Sent: 30 November 2014 21:21
To: Simon Davis; Planning
Subject: OBJECTION - planning application Y/93/14/OUT

I would like to object to the planning application Y/93/14/OUT proposed for the area opposite my house. As before with the application for 250 houses on the fields behind St. Mary's Church, Yapton neither has the infrastructure nor the facilities to support development of this size.

DRAWING NO YAP/DR/1

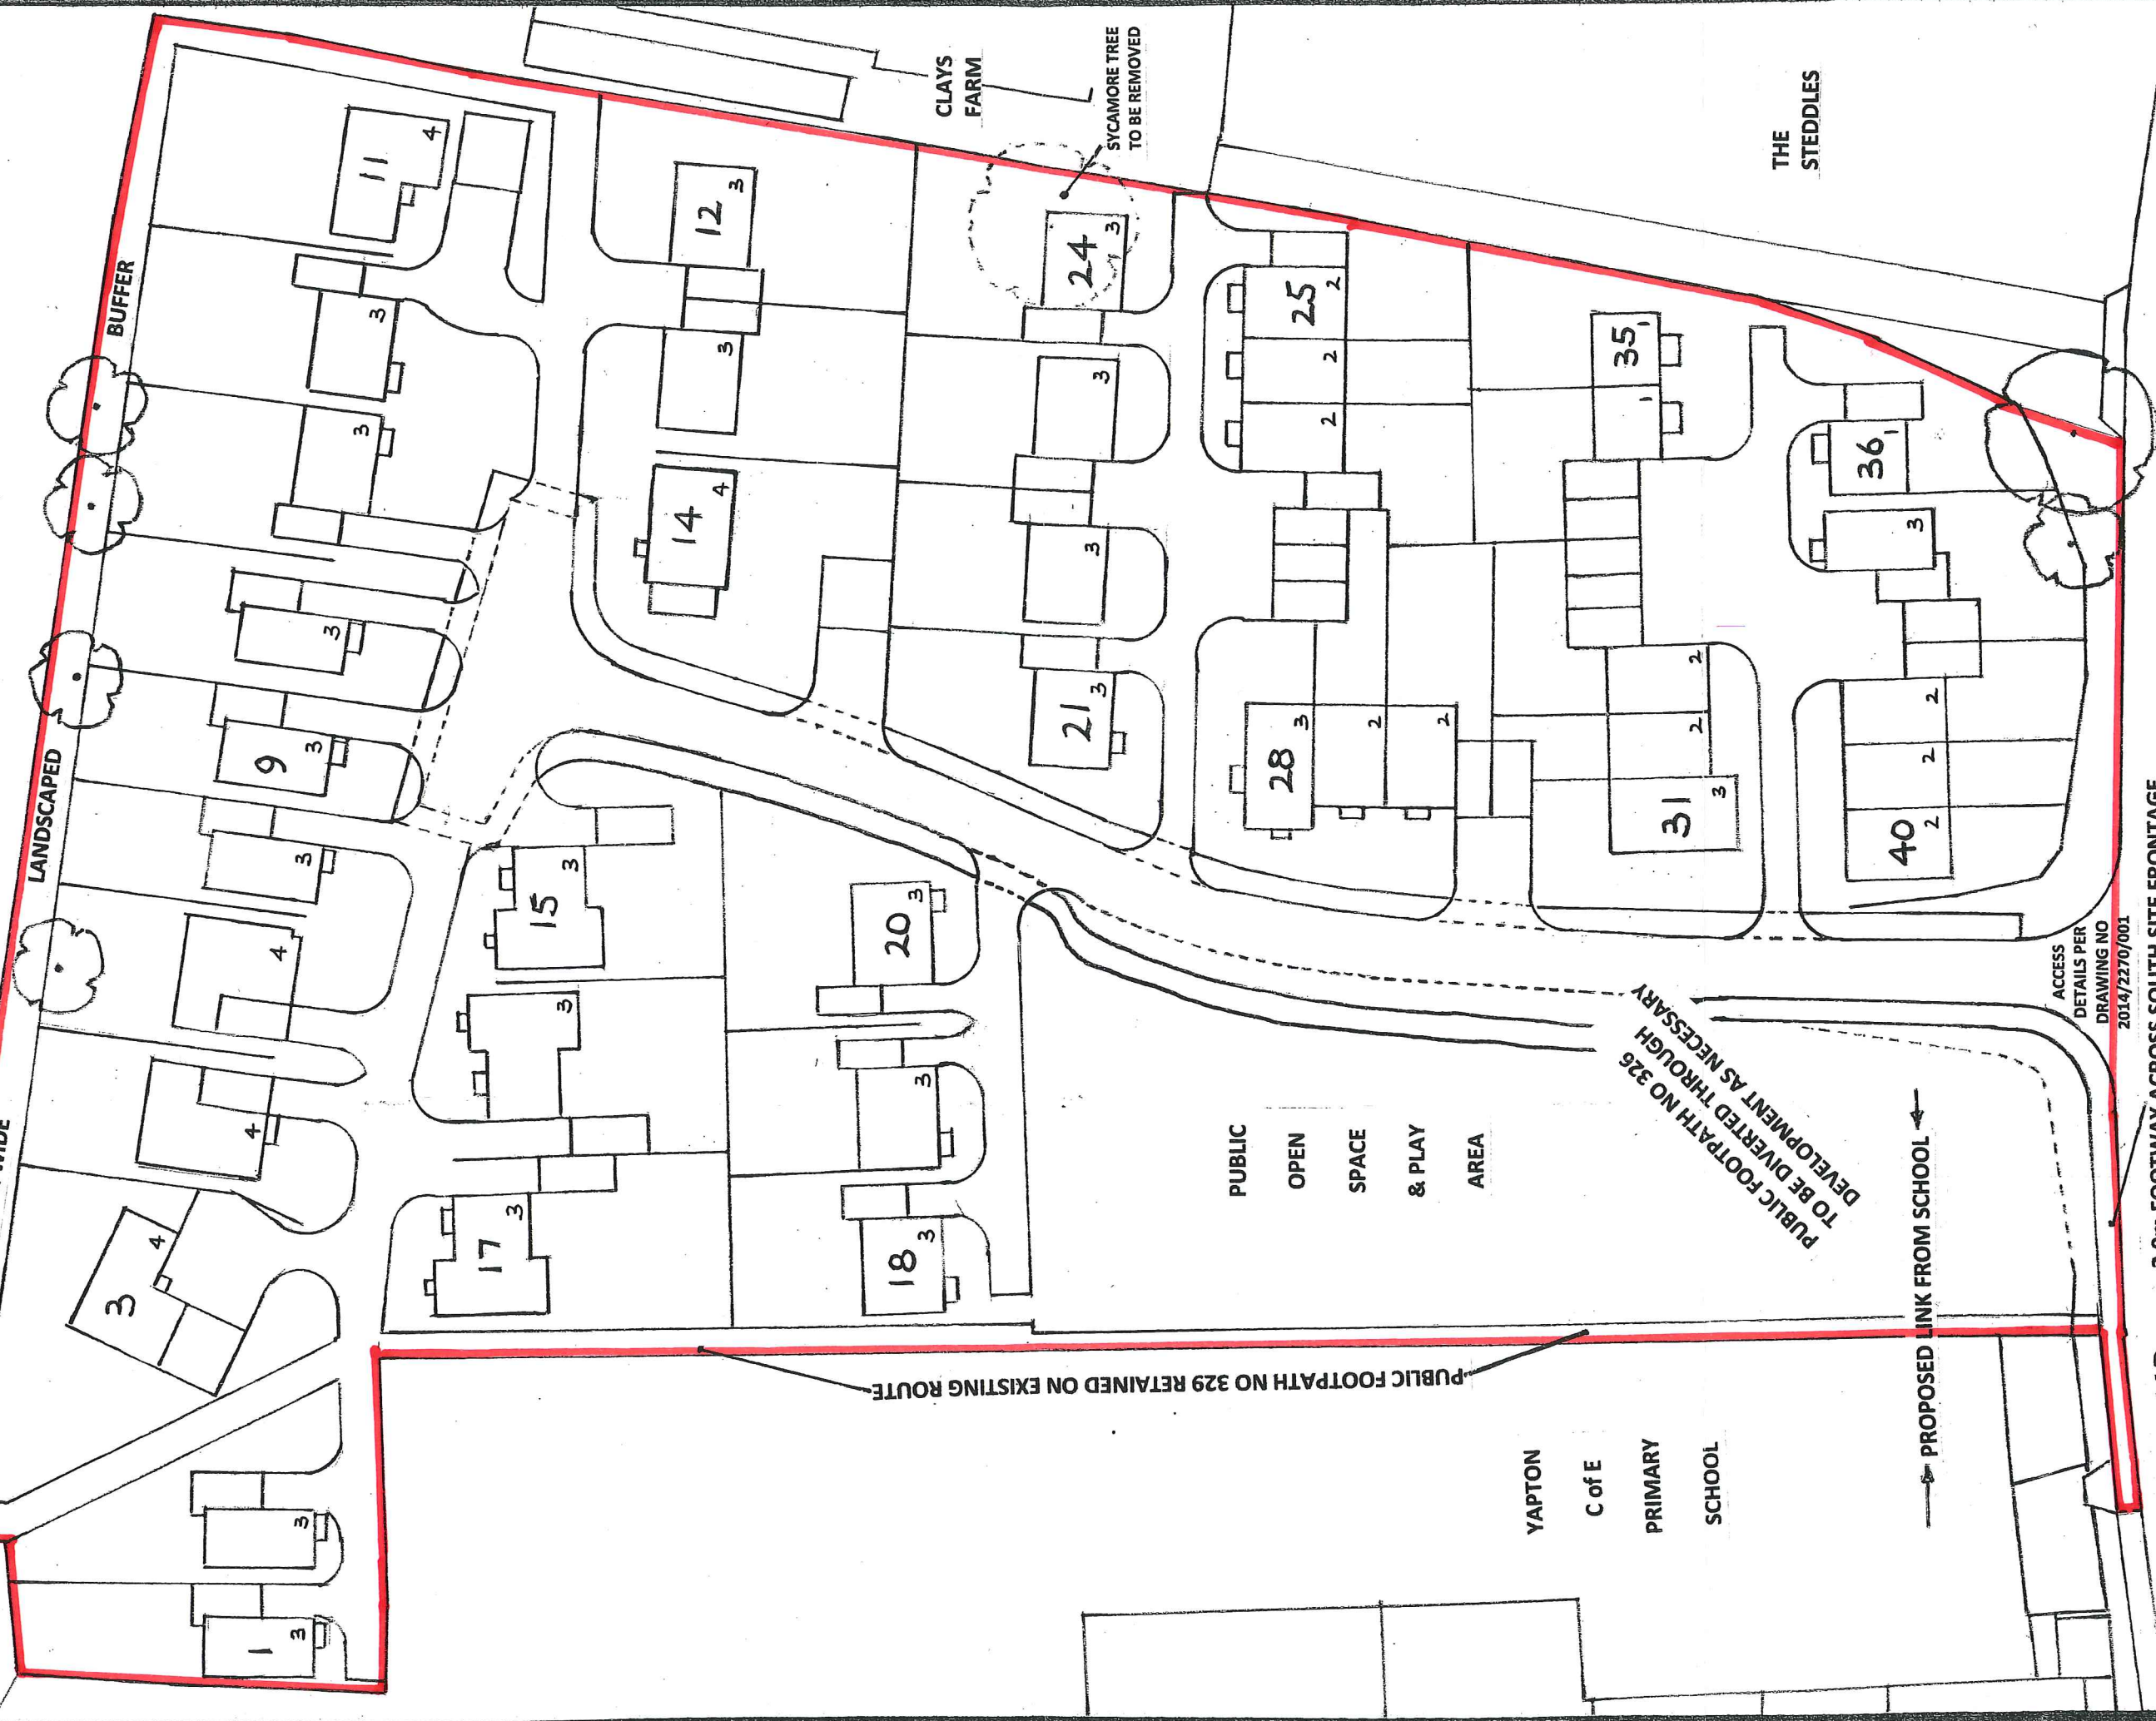
I note that the original proposal for 20 houses has been increased at the last moment to 38. Surely it is plain to see that the development is purely a financial gain for the developer and offers nothing to the village at all. This can be demonstrated by the lack of parking spaces in the proposal; North End Road is hardly well served by public transport so any development must allow for ample parking of private vehicles.
